10/28/2024  
Project #010014-01-218

**RE: PR-2021-004973 CHICK-FIL-A 1600 GIBSON BLVD SE**

Bowman Consulting is in receipt of your comment letters, regarding the above-mentioned Plans Review for PR-2021-004973 CHICK-FIL-A 1600 GIBSON BLVD SE. Please see the following response for further clarification as requested:

**4 TREE PLANTING DETAIL**  
1" = 50" P-CH-20

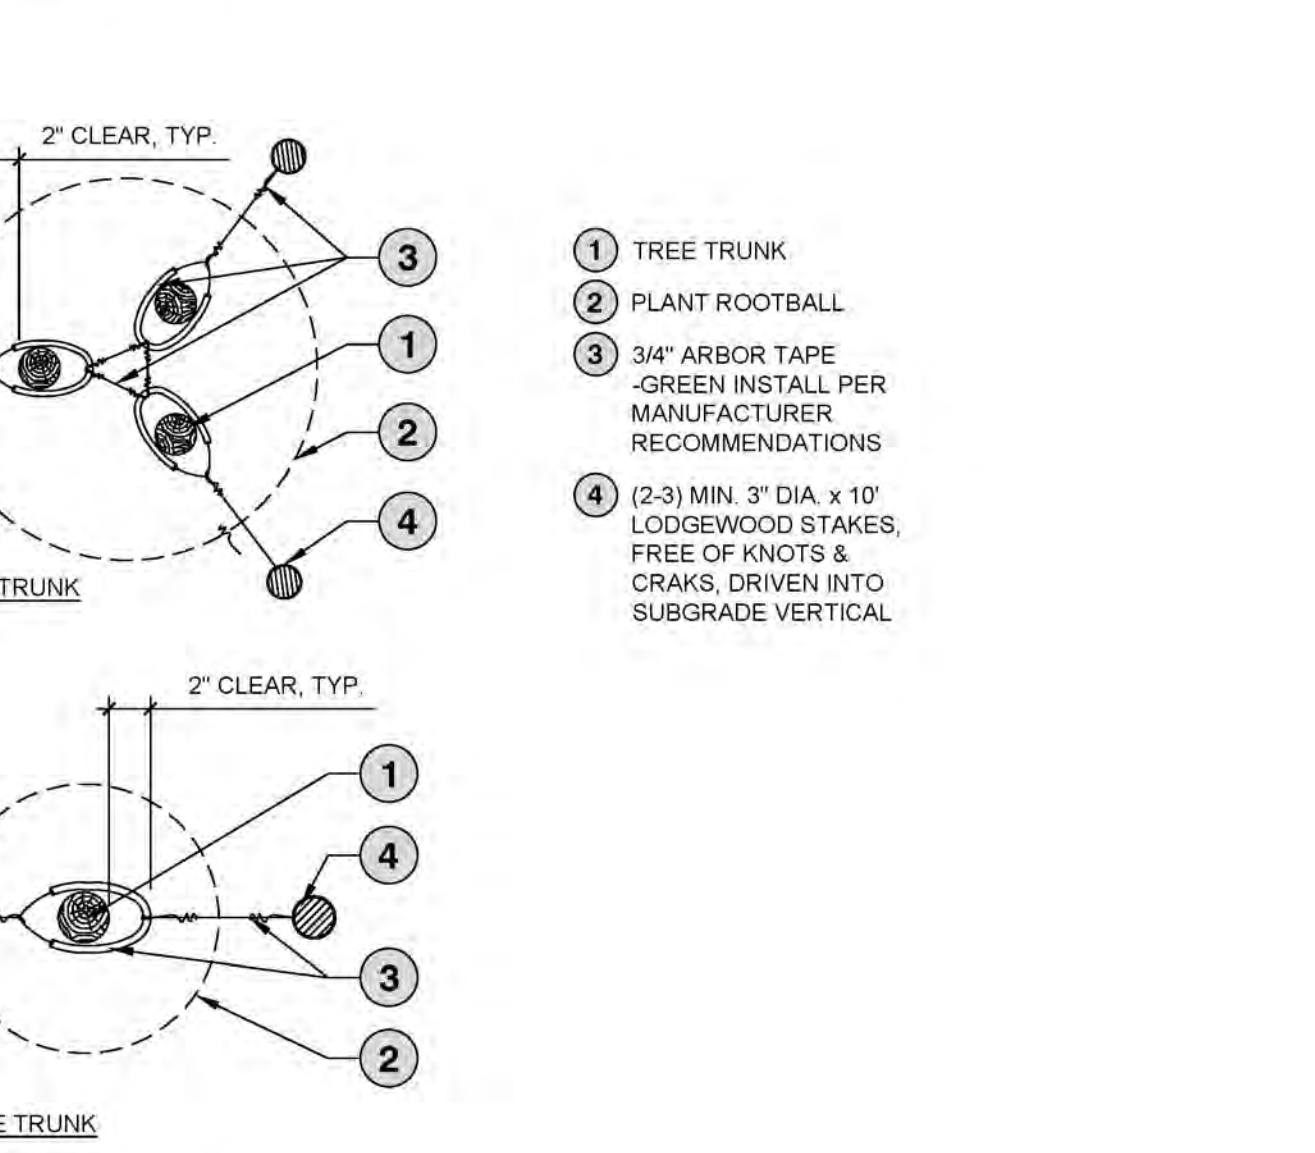
Comment #1: 5' radius organic mulch around all tree trunks must be shown on all tree planting details. Please correct this on tree planting details of page L3.

**Response:** Detail 4 on Sheet L3.0 has been updated. Please see detail keynote #15 and dimensions on the revised detail.
